Recommendation Report for Planning Permission for Works or Extension to a Dwelling

REF NO: BR/85/19/HH

LOCATION: 31 Devonshire Road
Bognor Regis
PO21 2SY

PROPOSAL: New 1st floor extension over rear projection.

sheet 2 of 3

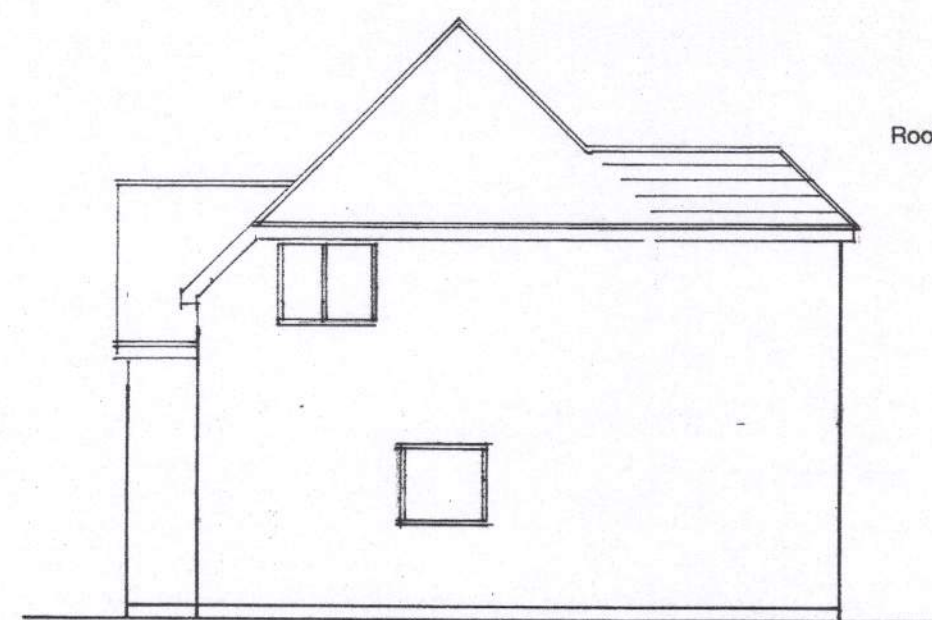
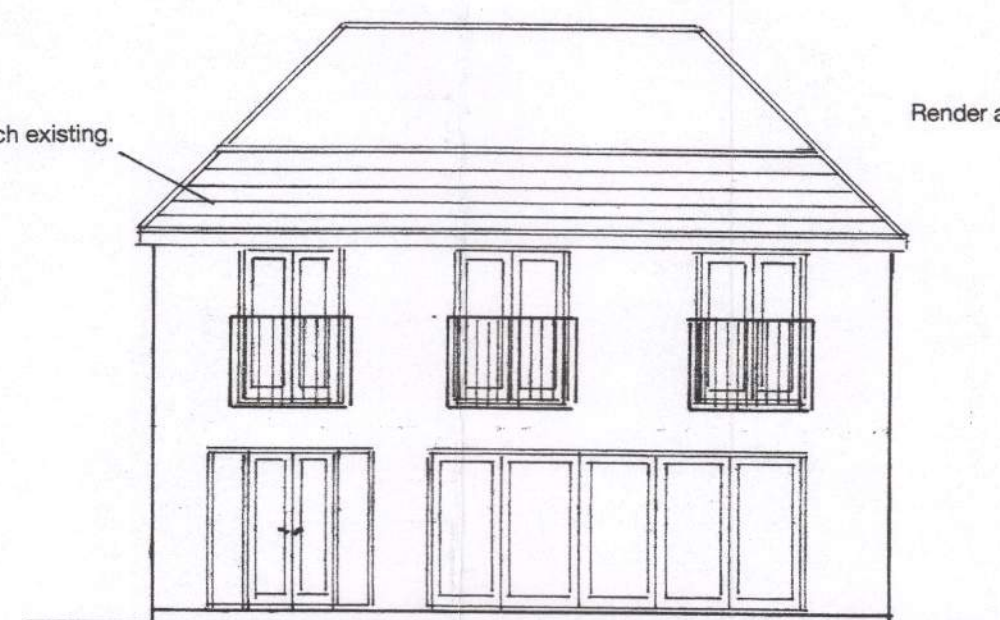
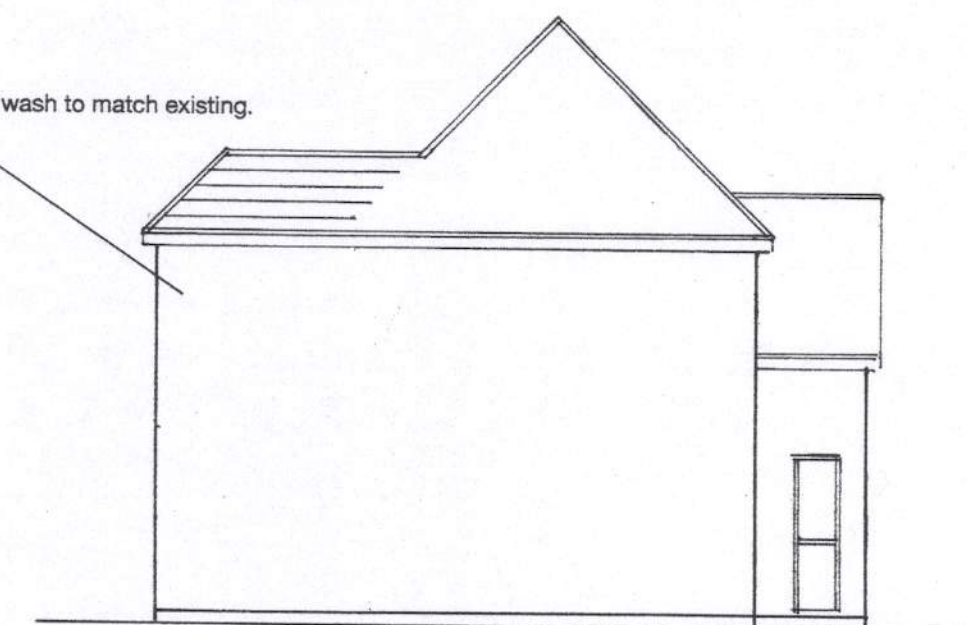
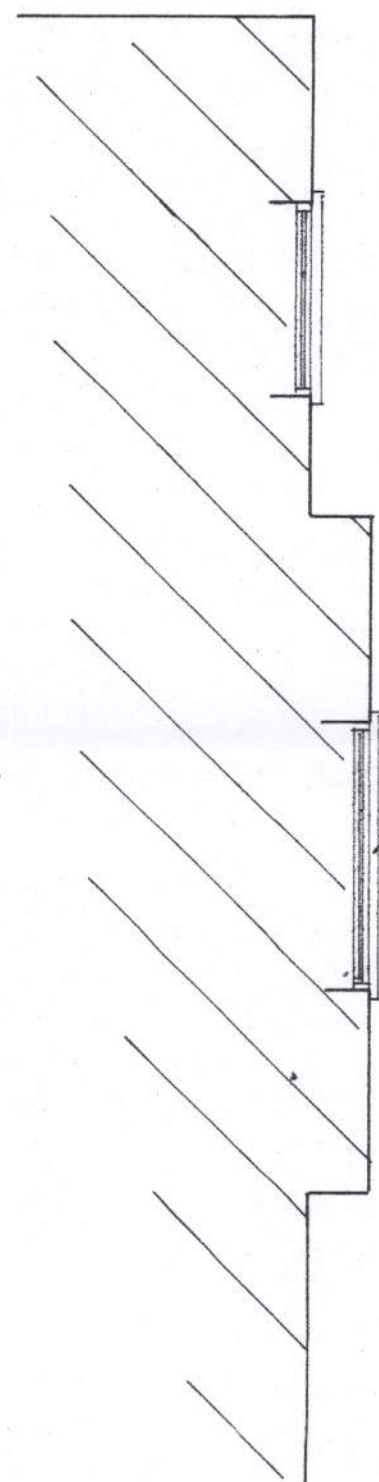
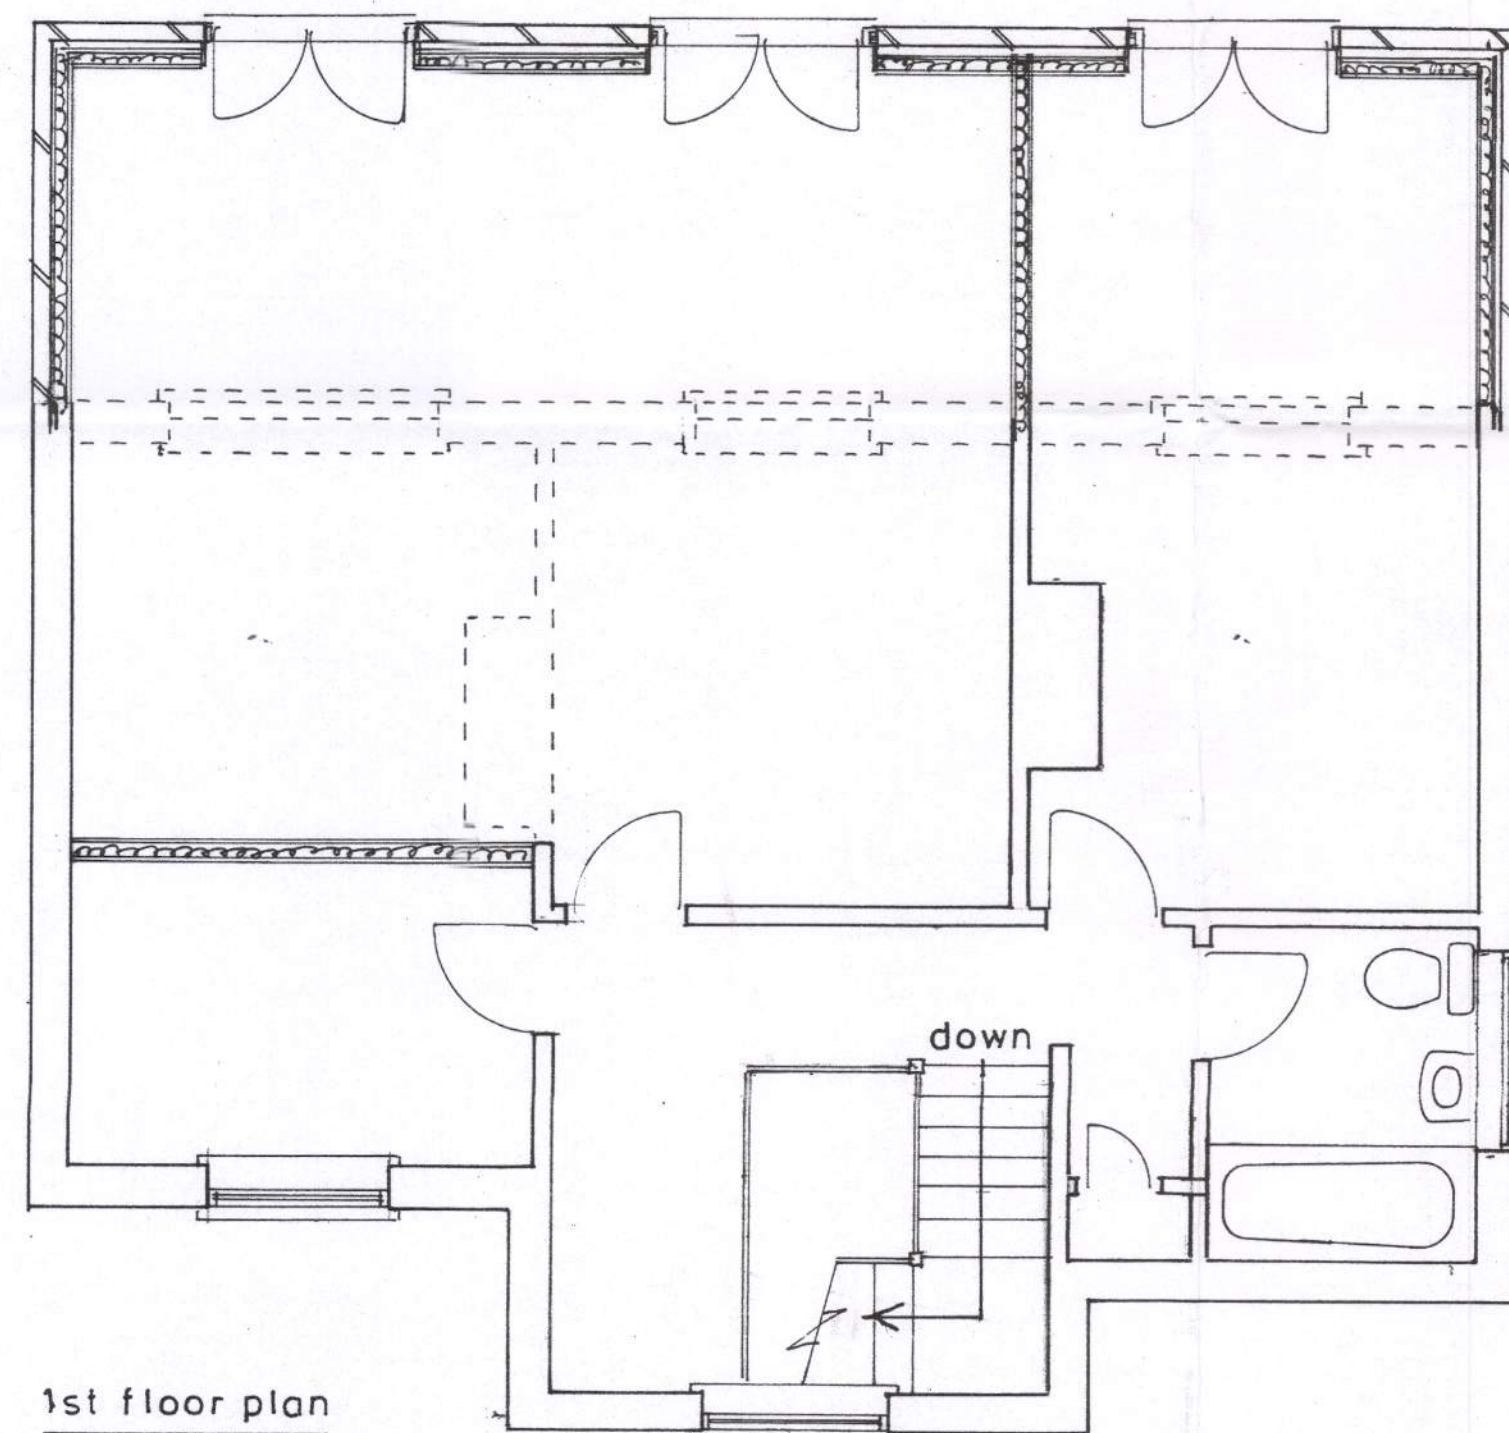
The development will construct a first floor extension over an existing 3m rear addition. The addition of a first floor is considered to impact upon the windows sited to the western elevation at No.29 however the development does not intersect a 45 degree line when drawn from the centre of the windows which is the tool used to assess serious effects on neighbouring properties daylight, sunlight and overbearing impacts caused. As a result any impacts are not considered significant in which a refusal is justified.

The roof will be flat hipped which slopes in line with the existing roof to a height 1.7m below that of the host dwelling and eaves to match. The development proposes 3 Juliet balconies to the rear first floor. Juliet balconies would also ordinarily fall under permitted development. They are therefore not considered to give rise to adverse overlooking additional to that which can already be achieved with windows already located at first level albeit they will increase slightly in depth. The rear elevation of the dwelling also sits behind that of the both neighbouring properties with 21m retained to the rear boundary.

Whilst there would be an impact on the amenities of neighbours (in particular no 29) it is not considered that the extension would cause such harm as to warrant a reason for refusal. The side facing kitchen window of no 29 would be affected via overshadowing/loss of light. However the kitchen benefits from a large window facing down the garden. The upstairs bedroom window of no 29 would have a loss of some light. However as a bedroom the time spent in the room during the day time is limited and as such the impact of the extension does not justify a refusal.

There would be some additional overlooking to neighbours as the upstairs windows would be further down the garden. However the oblique views gained are not sufficient wo warrant a refusal.
